From: Martin Hill <Martin.Hill@arun.gov.uk>
Sent: 20 December 2021 12:59
To: Planning.Responses <Planning.Responses@arun.gov.uk>
Subject: RE: Planning Consultation on: BR/261/21/PL

Comments from Private Sector Housing:

Application No: BR/261/21/PL
Registered: 23rd November 2021
Site Address: 7 Longford Road Bognor Regis PO21 1AA
Grid Reference: 493352 99452
Description of Works: Retention of 6 bed HMO. This site may affect the character & appearance of the Bognor Regis Railway Station Conservation Area & is in CIL Zone 4.

Drawing Title:  
PROPOSED PLANS AND ELEVATIONS  
6 BED, 10 PERSONS HMO

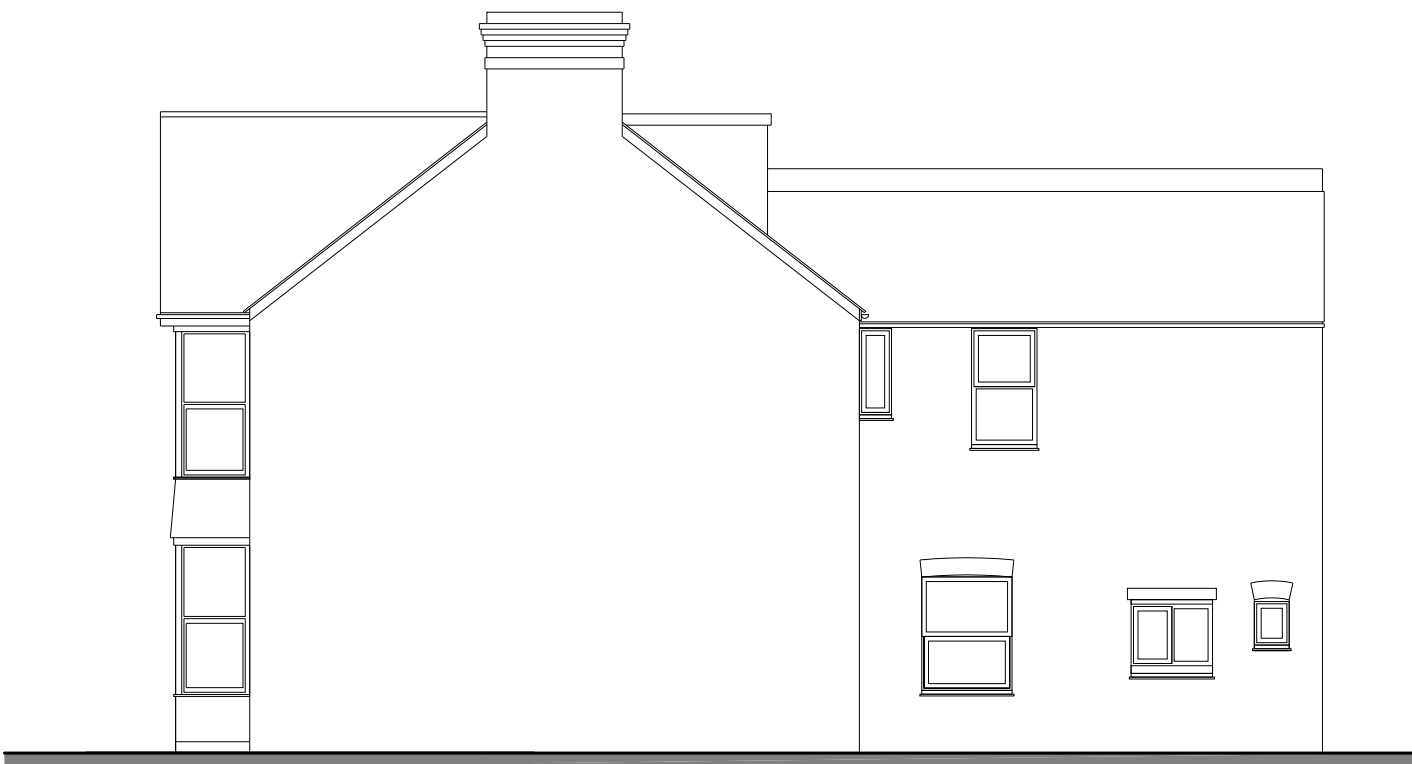
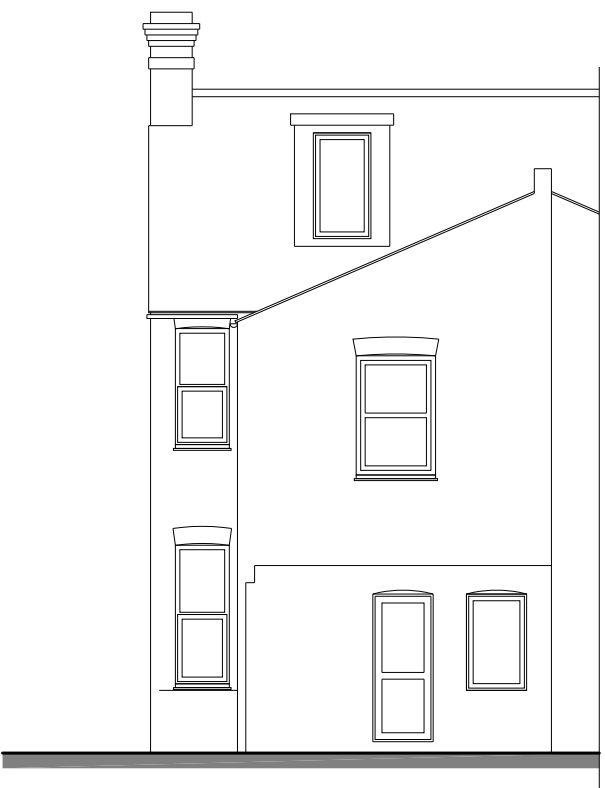
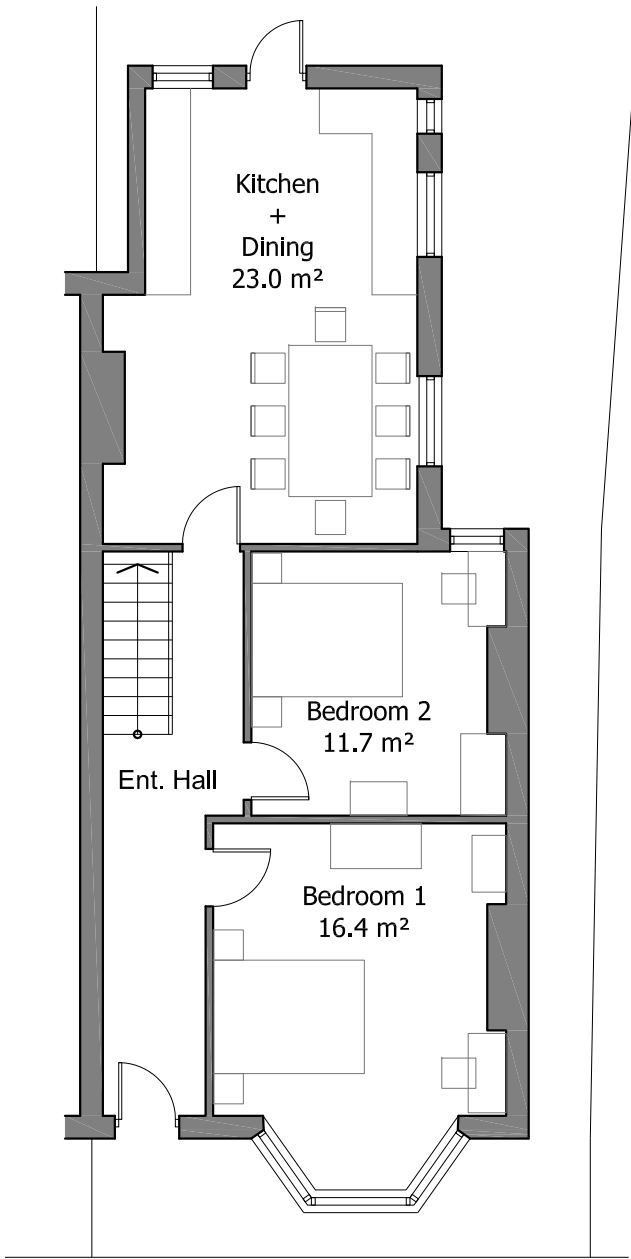
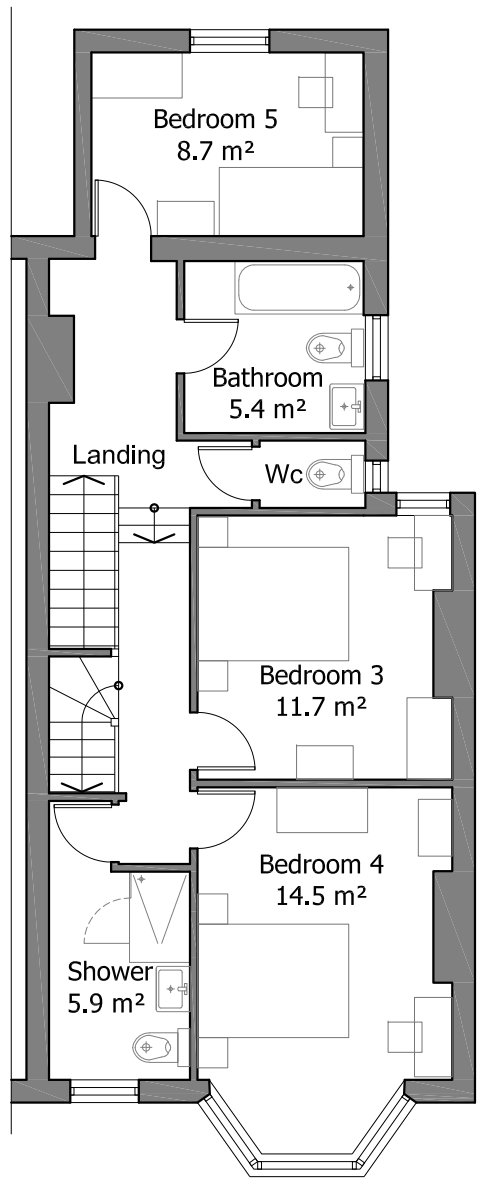
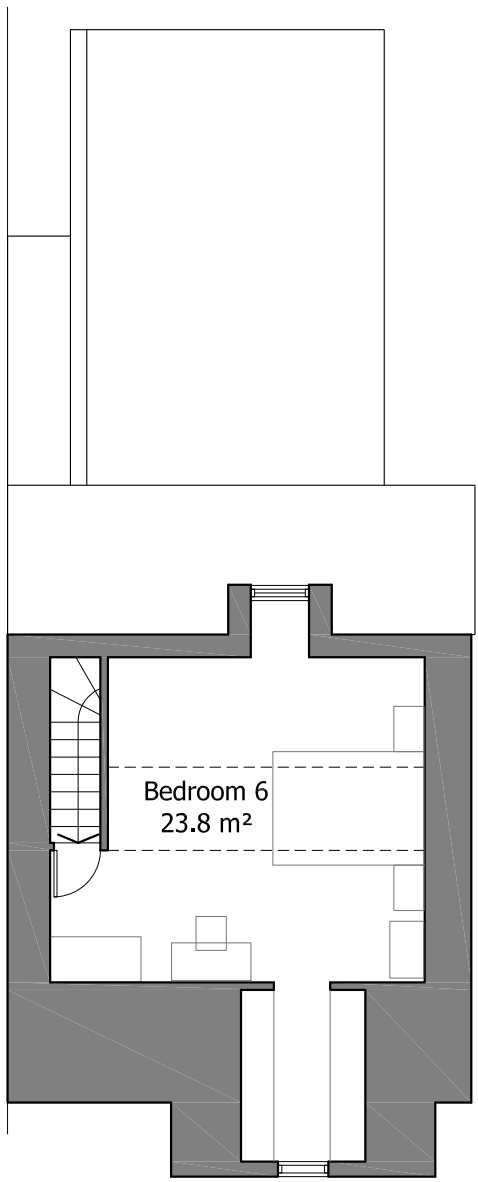
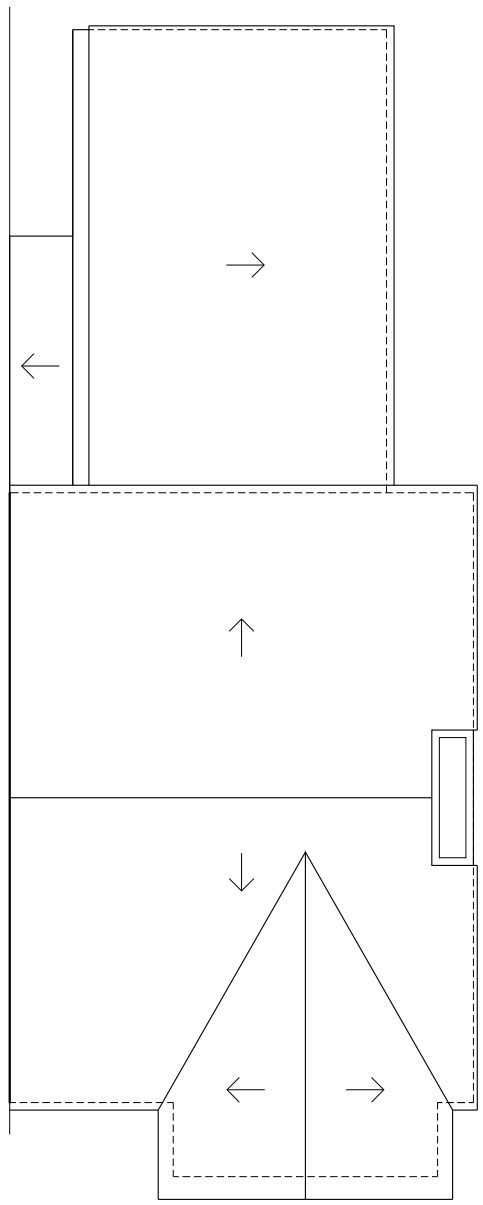
- Any property that has 5 or more people sharing facilities will require a license from the Council and the property must meet minimum standards.
- The proposed plans for this property indicate that it would be suitable to accommodate up to 10 persons.

- All habitable rooms must have an opening window, equivalent to 1/20th of the floor area, to the outside air to provide adequate ventilation. Particular attention should be paid to bedrooms 2 & 3 in this regard. French or patio doors that have no separate openable casements, or where there is no alternative openable casement within the room, are not considered acceptable in bedrooms.
